M60/M62/M66 Simister Island Interchange Project

The Examining Authority's (ExA) Consultation draft Development Consent Order (dDCO)

Schedule of ExA's recommended amendments to the applicant's dDCO submitted at Deadline 5 [REP5-005]

Reproduced by permission of Ordnance Survey on behalf of HMSO. © Crown copyright and database right 2024. All rights reserved. Ordnance Survey Licence number 100030649.

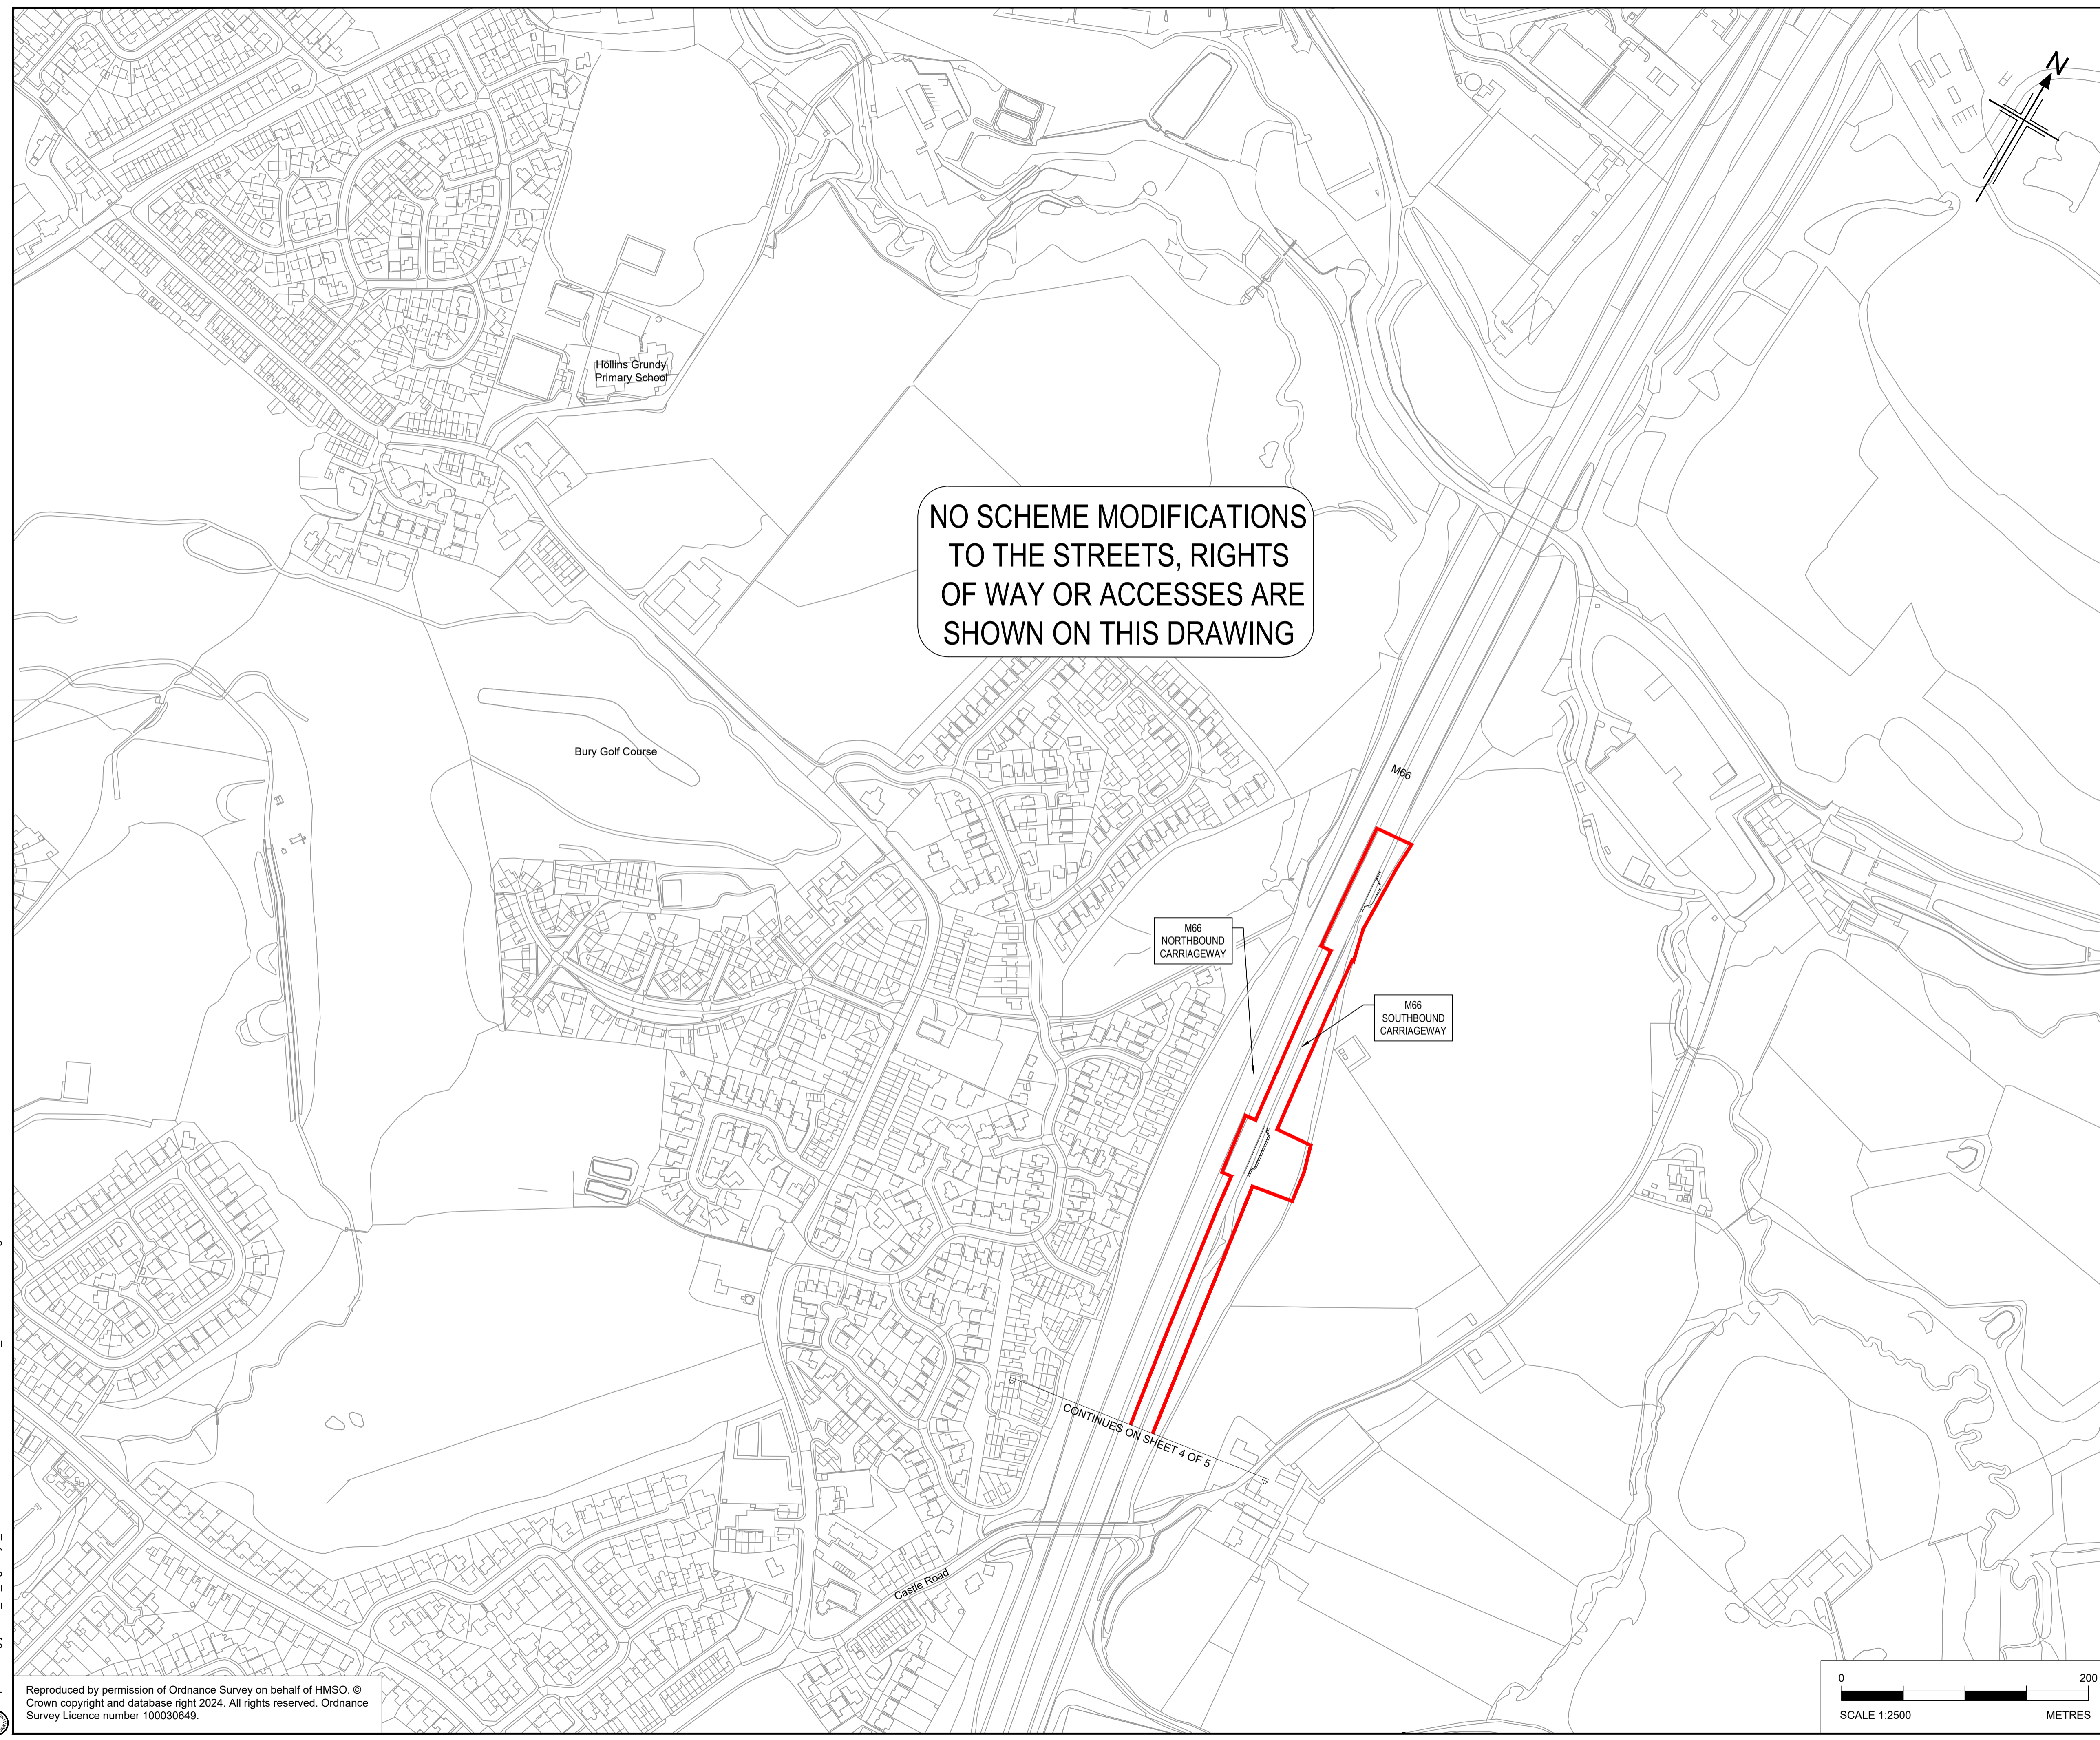
5.	13. Classification of roads etc.	(4) The private means of access specified in column (2) of Part 3 (private means of access) of Schedule 3 and identified on the	(4) The maintenance accesses and private means of accesses specified in column (2) of Part 3 (private means of access) of	To improve precision by clarifying that the article also includes the 'maintenance accesses' as identified on the Streets, Rights of Way & Access

No.	Article / Schedule	Text as set out in the draft DCO [REP5-005]	ExA's Recommended Amendment	Reason and Notes
		streets, rights of way and access plans are to be constructed by the undertaker in the specified locations and open for use from the date on which the authorised development is open for traffic.	Schedule 3 and identified on the streets, rights of way and access plans are to be constructed by the undertaker in the specified locations and open for use from the date on which the authorised development is open for traffic.	Plans [APP-008], noting the applicant's response to ISH1 Action Point (AP) 8 [REP1-024] that the article is intended to cover both the both the maintenance access tracks listed in Schedule 3, Part 4 and the private means of access.

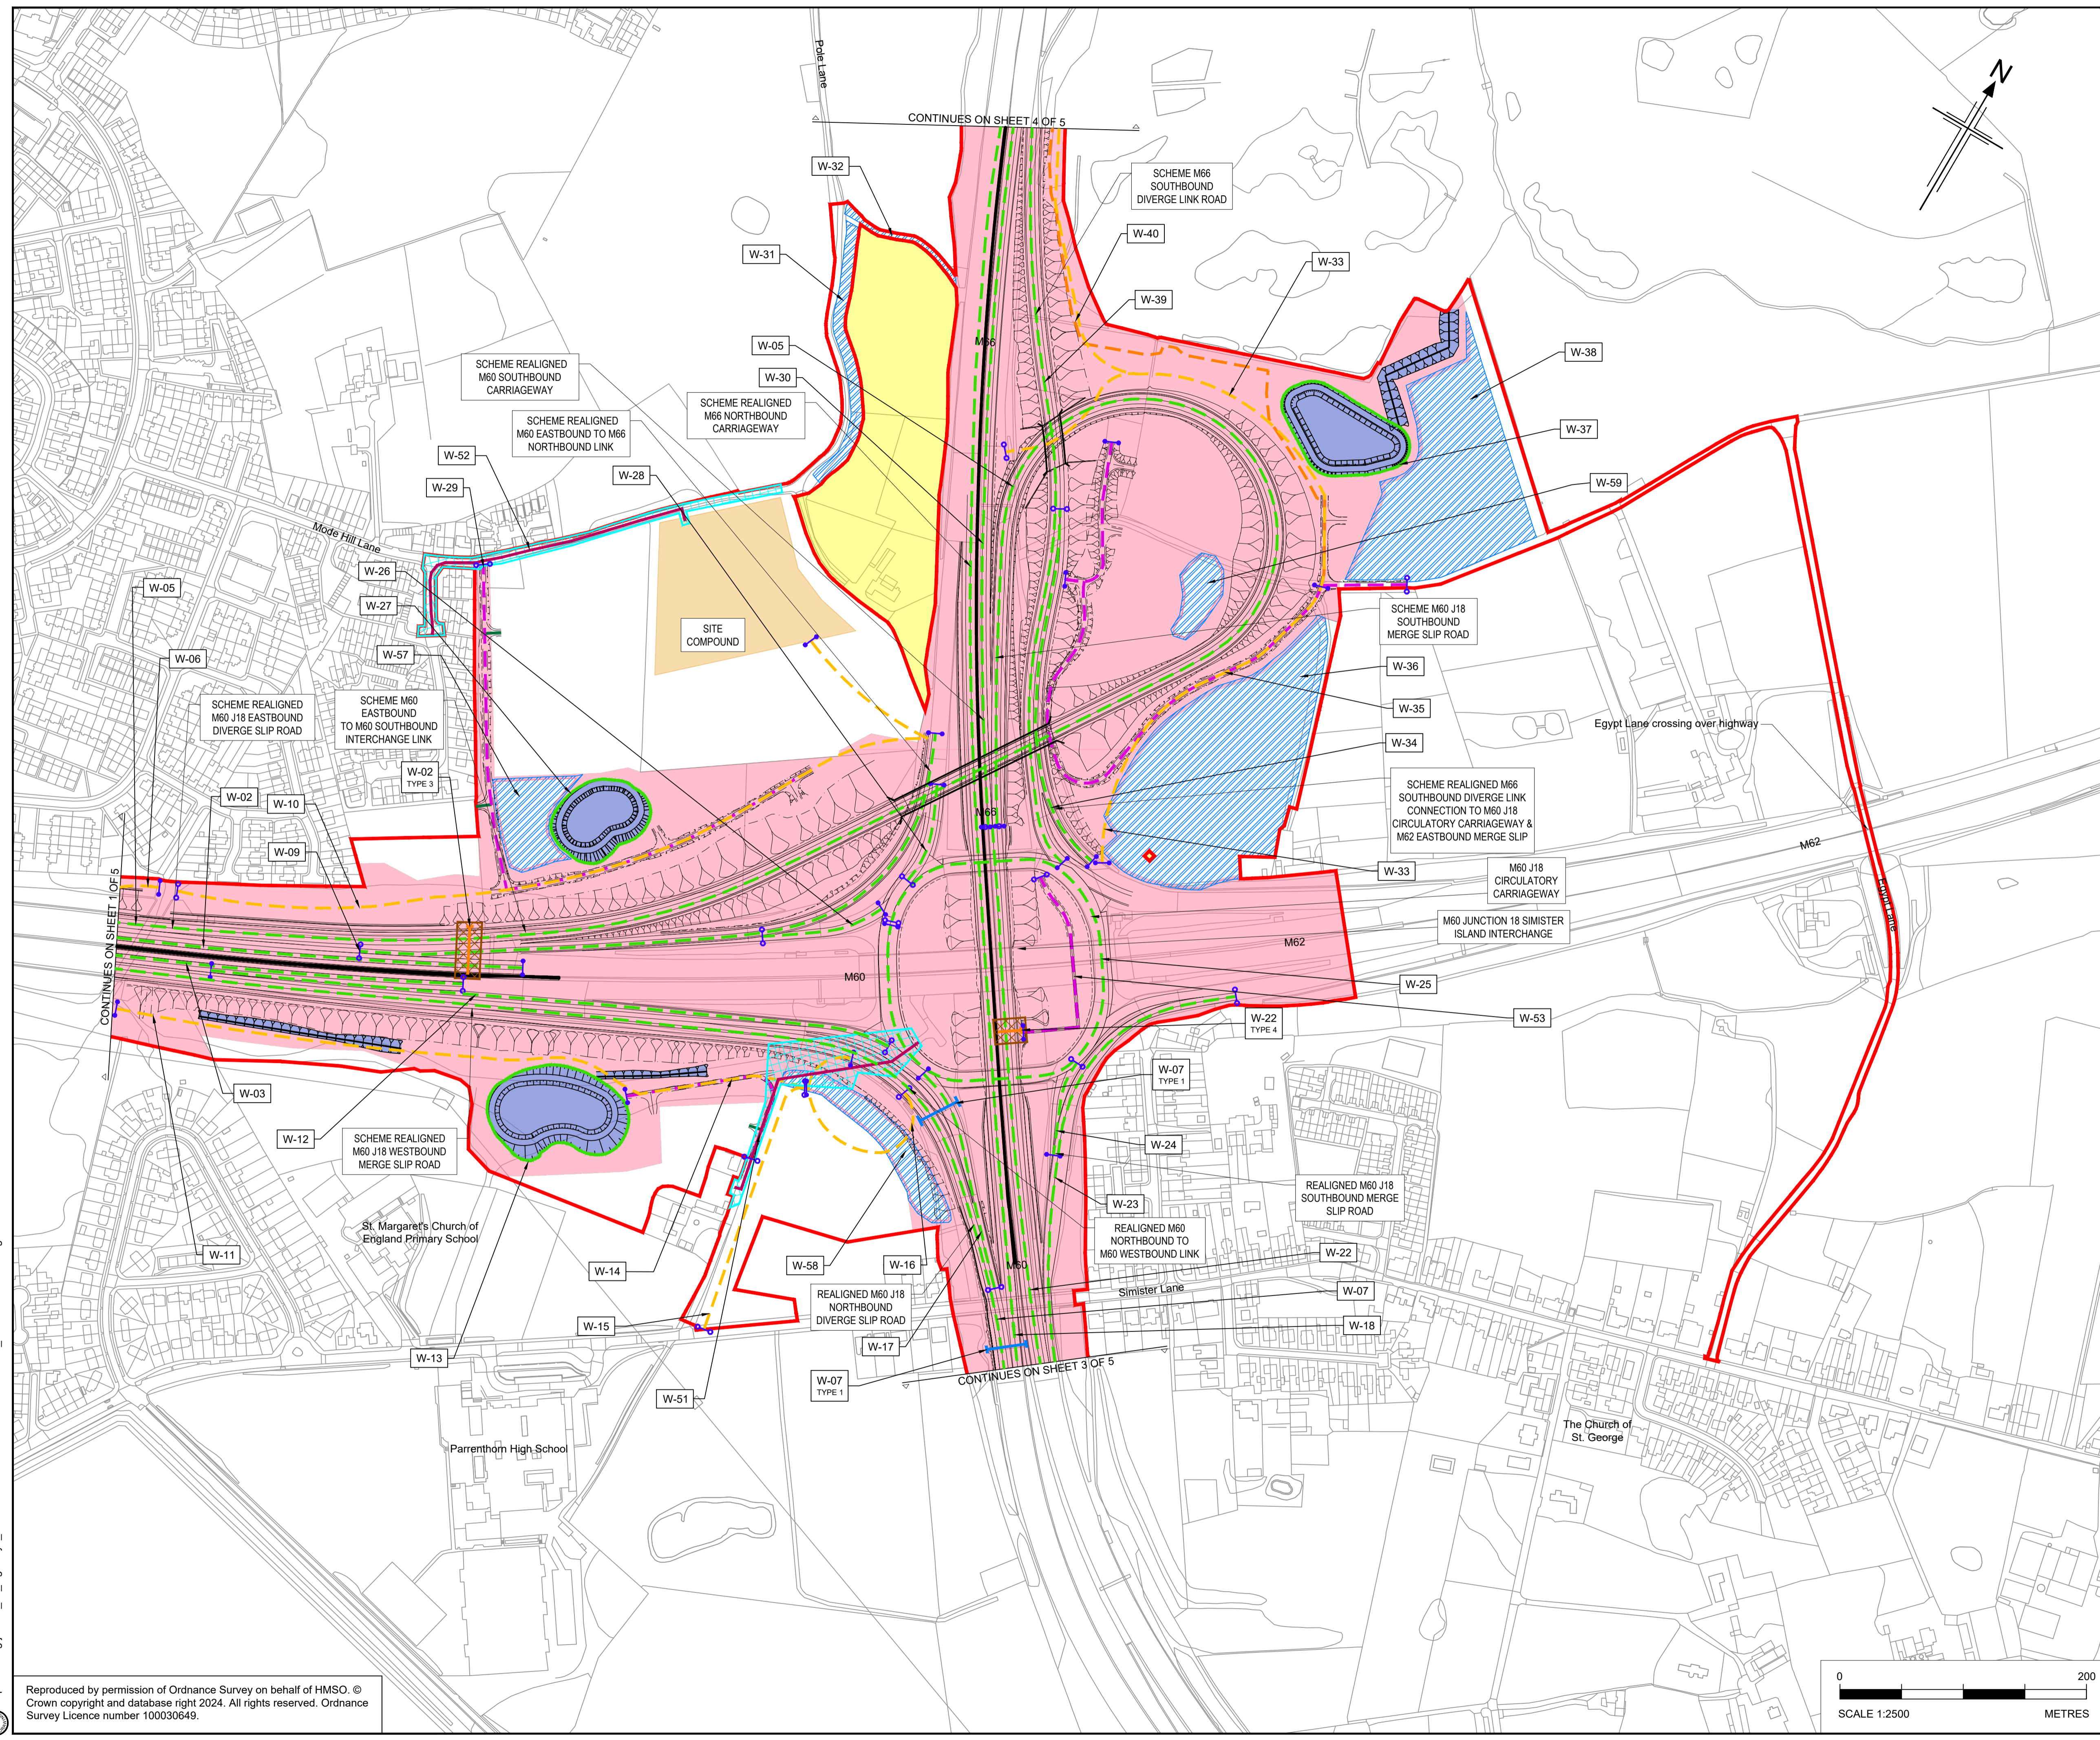
16.	Work No. 38	Work No. 38 – shown on sheet number 2 of the works plans as being the establishment of environmental mitigation areas to the north east of M60 Junction 18 and north of Egypt Lane, including woodland planting, hedgerow planting and species rich grassland. Works to Important Hedgerow (HG_80) as described in Schedule 8 of this Order.	Work No. 38 – shown on sheet number 2 of the works plans as being the establishment of environmental mitigation areas to the north east of M60 Junction 18 and north of Egypt Lane, including woodland planting, hedgerow planting and species rich grassland. Works to Important Hedgerow (HG_80) (HG_23) as described in Schedule 8 of this Order.	To correct an error.
Schedule 2, Part 1 Requirements
